# Agency Review Comments

Humphrey Platte Ave Self Storage

PPR2418

## Review Comments (30)

WATER & UTILITY SERVICE PLAN
COVER SHEET

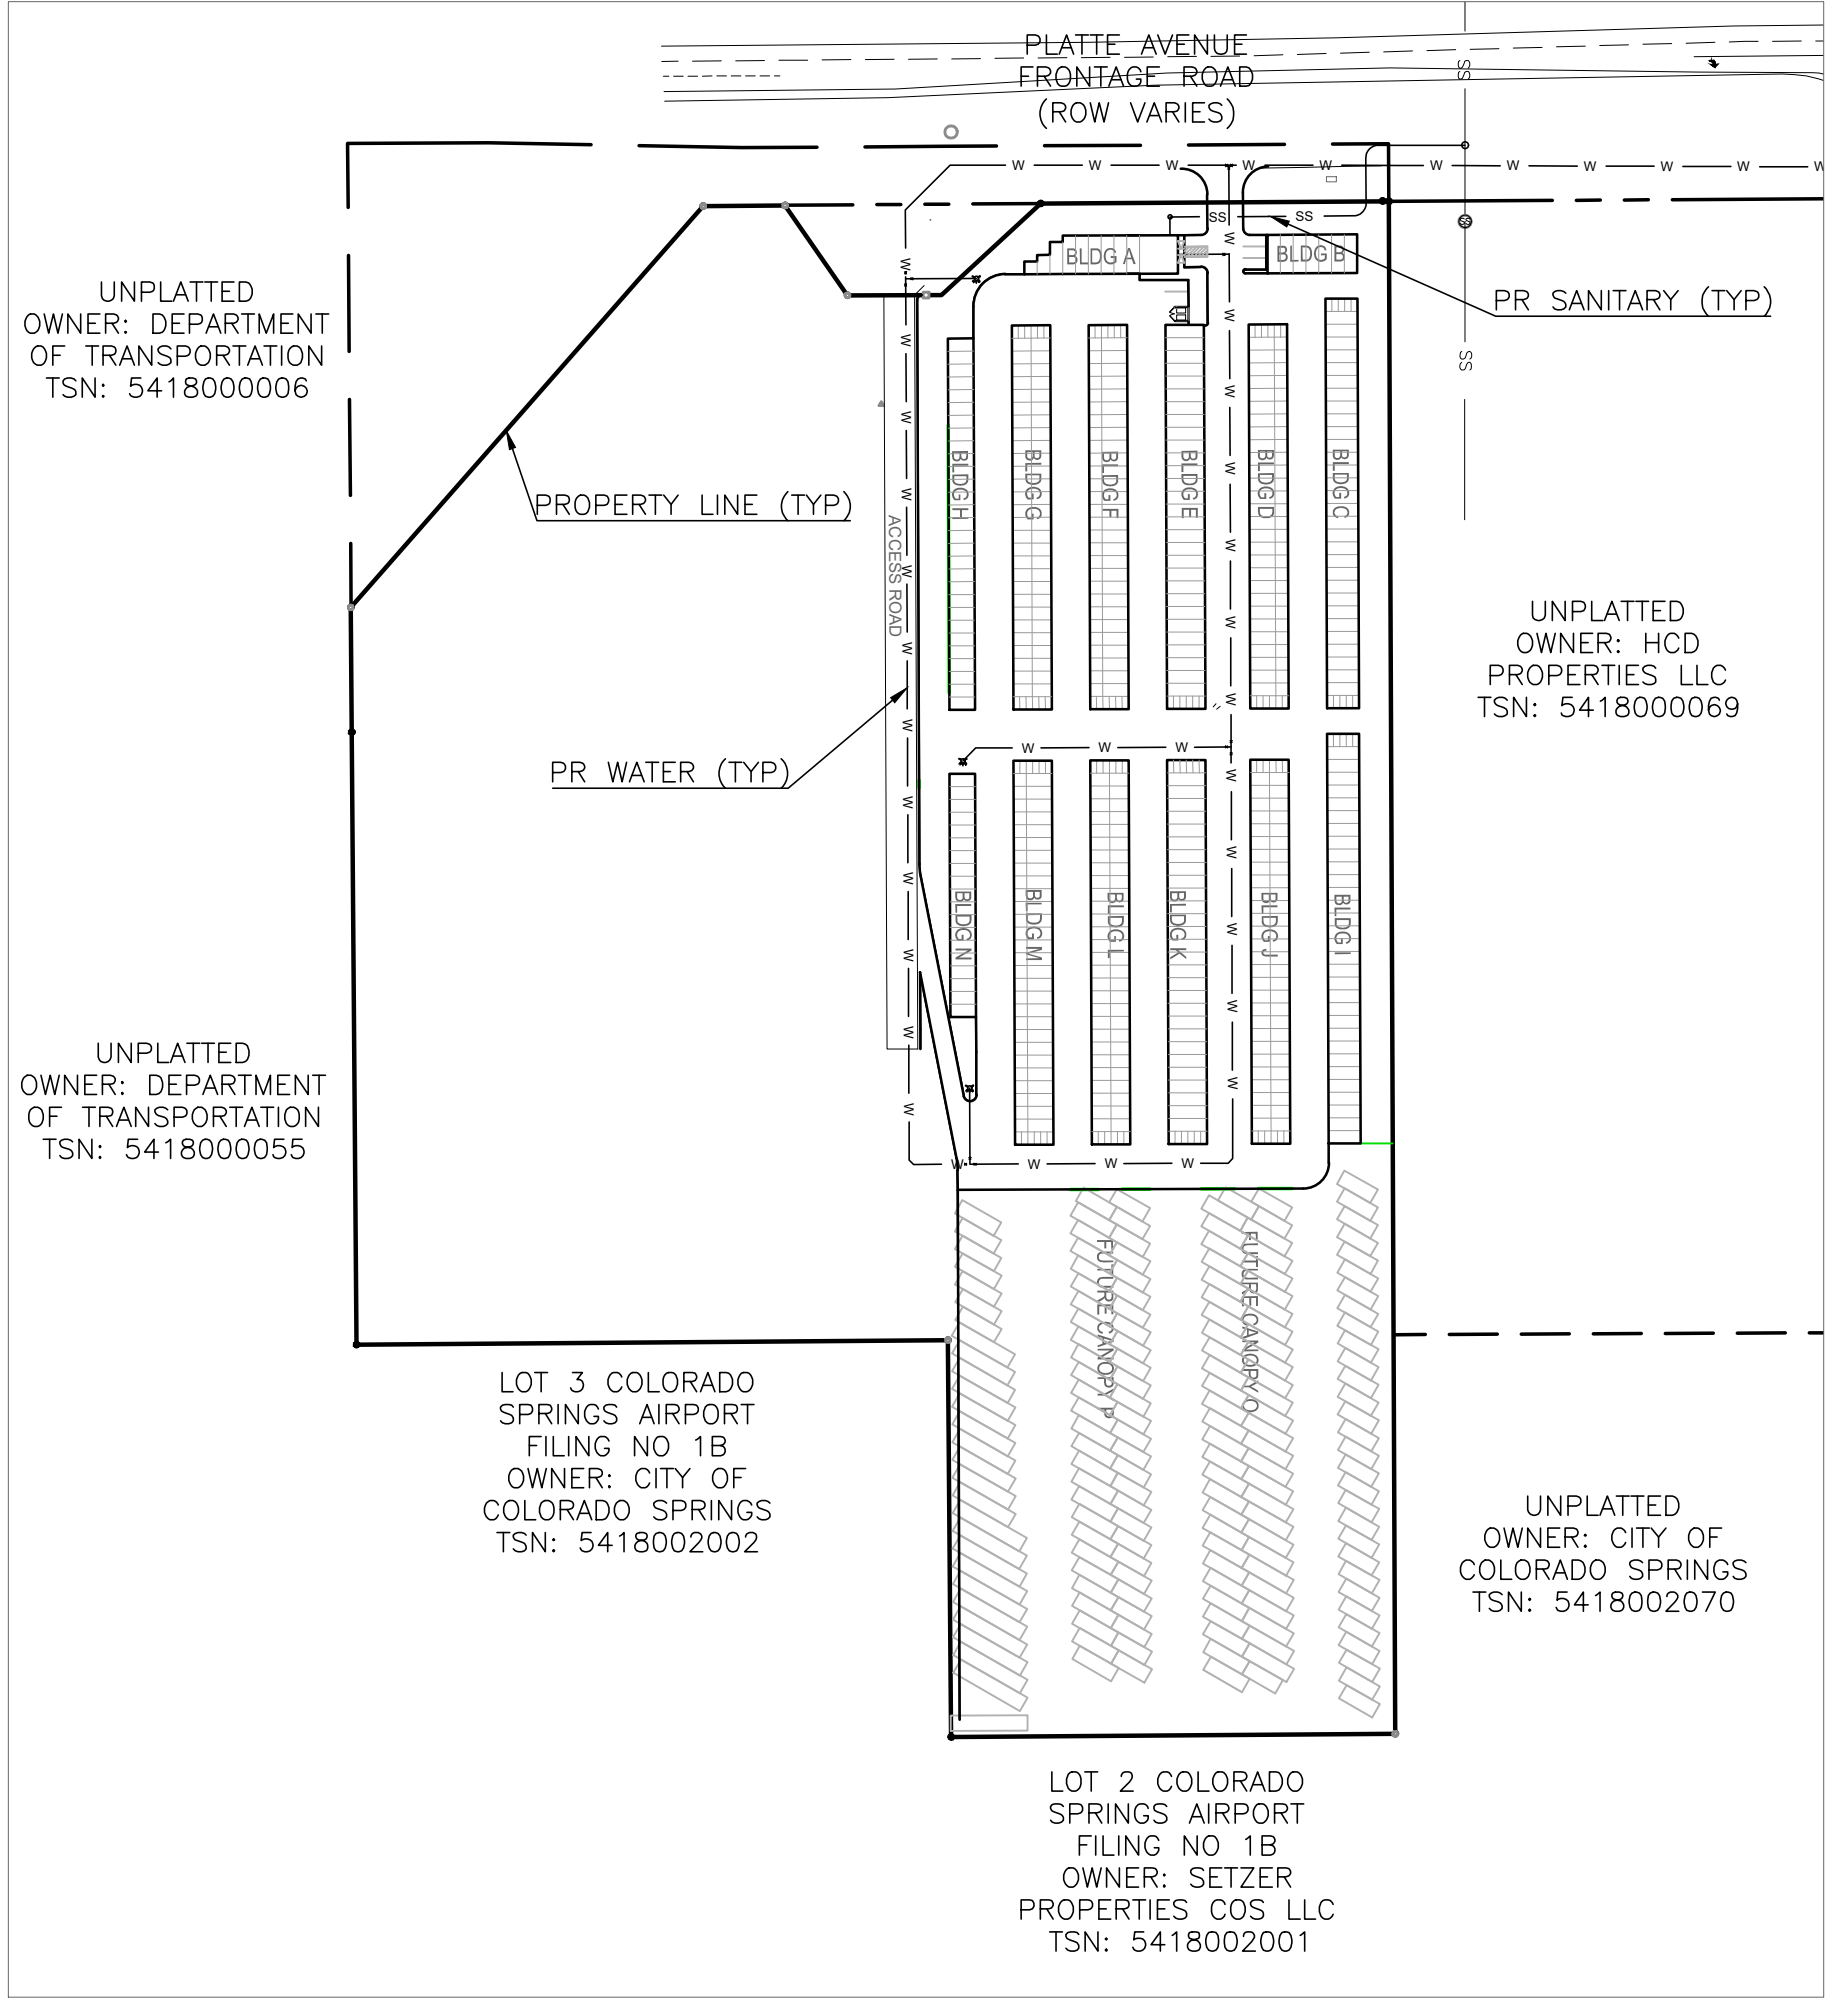
Cherokee Metro Dist		10/1/2024 3:16:56 PM
Cherokee Metro Dist	<p>All comments are in reference to the "Water &amp; Utility Service Plan"</p> <p>On page 1, cover page, under general notes and water plan notes it should state that methods and materials shall meet Cherokee Metropolitan District's standards.</p> <p>On page 2, it should state that manholes to Cherokee standard are a minimum of 5' Internal diameter.</p> <p>Additionally, on page 2, a sanitary tie in detail to the existing force main needs to be included within the utility plan (it can be on a sheet at end of utility plan).</p> <p>On page 3, include within the open area a utility crossing table with all proposed lines crossing existing; include both water and sanitary lines for the crossing table and identify on plan. I have also attached marked up sheet of page 3 and page 5, "water plan overview" and "water main plan &amp; profile", from our District's locator. Add the Blue and Red marked notes to the respective sheets.</p> <p>Additionally, throughout the "water &amp; utility service plan", starting on page 2 and going to page 7. All HDPE pipe that is on public road needs to be changed to PVC (this is because Cherokee Metro does not have the equipment to do HDPE line fixes). Lines that are in Private roads can stay as is.</p>	10/1/2024 3:14:02 PM
